Eggborough CCGT - Examining Authority's Written Questions

The following table sets out the Examining Authority (ExA)'s Written Questions and requests in relation to the Eggborough CCGT.

INDICATIVE COFFERDAM ARRANGEMENT
(COOLING WATER DISCHARGE POINT)

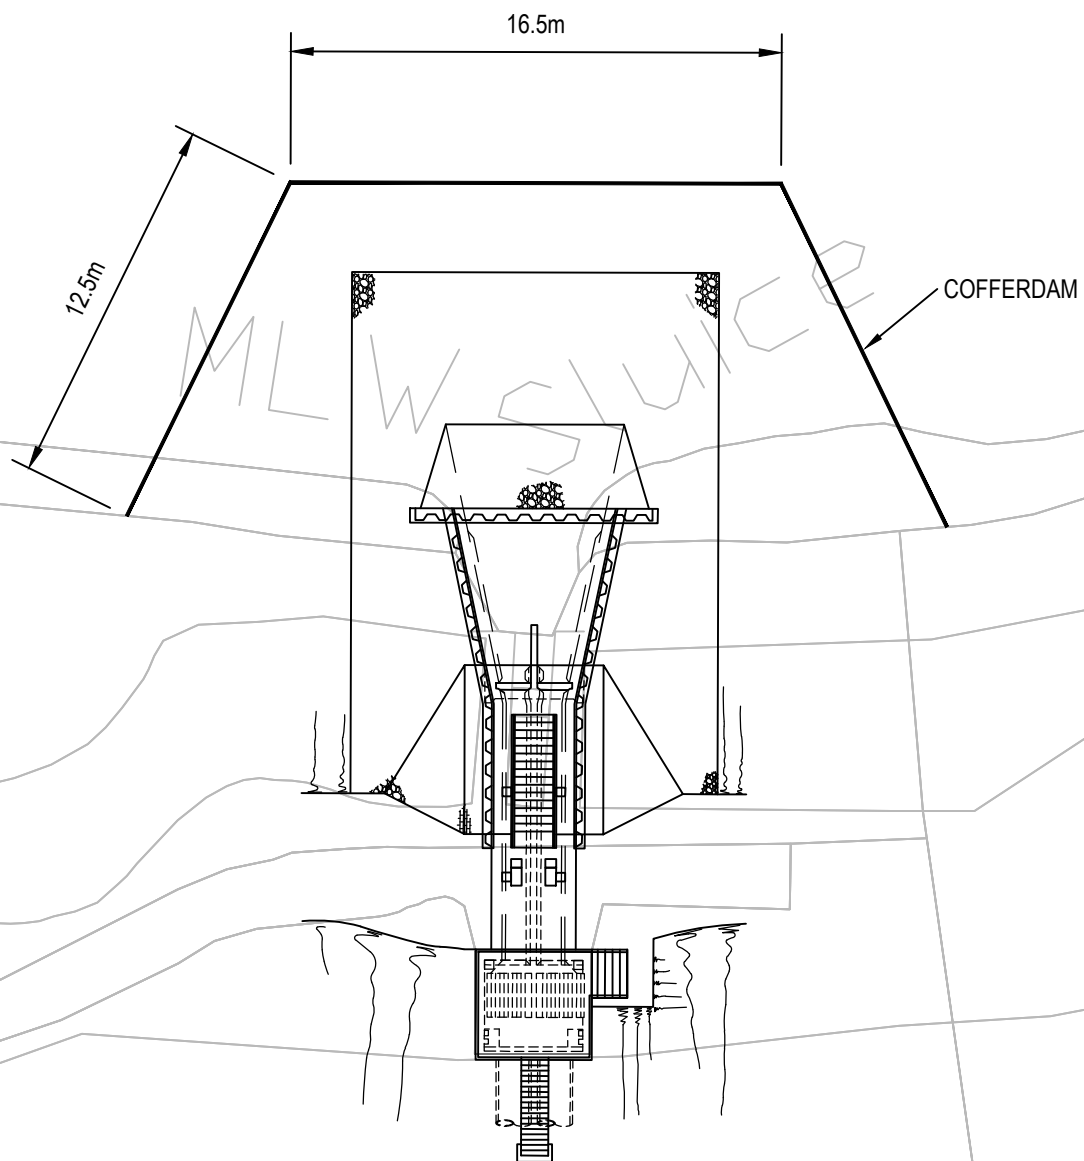
FW 1.11	<i>Cofferdam Removal</i> The Applicant Selby DC North Yorkshire CC The Environment Agency The Marine Management Organisation	<p>i) Comment on the need for a specific plan for cofferdam removal.</p> <p>For the Applicant:</p> <p>ii) If necessary, provide this plan.</p>
FW 1.12	<i>Indicative Construction and Environmental Management Plan</i> The Applicant	<p>The Canal & River Trust in its Relevant Representation [RR-008] requests that the measures proposed in paragraph 5.2.27 of the ES [APP-043] to limit potential environmental impacts of the cofferdams should be provided via condition within the draft DCO [APP-005]. Avoidance of installation in the salmonid migratory period is contained within the Framework CEMP [APP-099], however installation of the cofferdams during the summer/lower flow periods; and pre-construction sediment contamination testing are not.</p> <p>Respond and if necessary, rectify.</p>
